From: Simon Davis
Sent: 24 November 2020 15:48
To: [REDACTED]
Subject: AW/319/20/DOC - The Former Ship Inn Aldwick Street (Condition 2)

Our Engineer has provided the following comments:

Block Plan
scale 1:500 @ A1

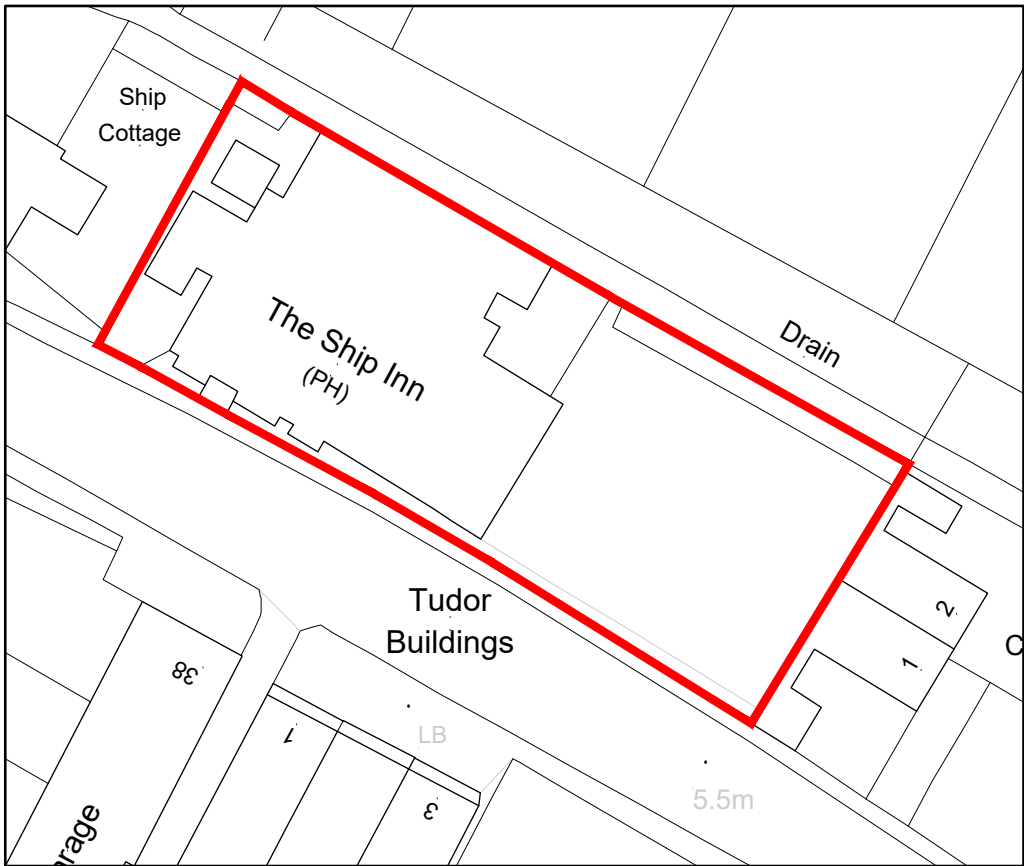
"Please can a plan showing the location of the proposed fence relative to top of bank of watercourse be supplied, what distance is being provided between the top of bank and the fence line? A 900mm access gate is suitable for pedestrian access. However, maintenance will likely require mechanical plant access. We therefore request that in addition a demountable fence is specified to permit access of mechanical plant as and when required. We would like to take this opportunity to remind the applicant that maintenance should be an annual activity. Vegetation, and litter should be managed each year and desilting undertaken as required."
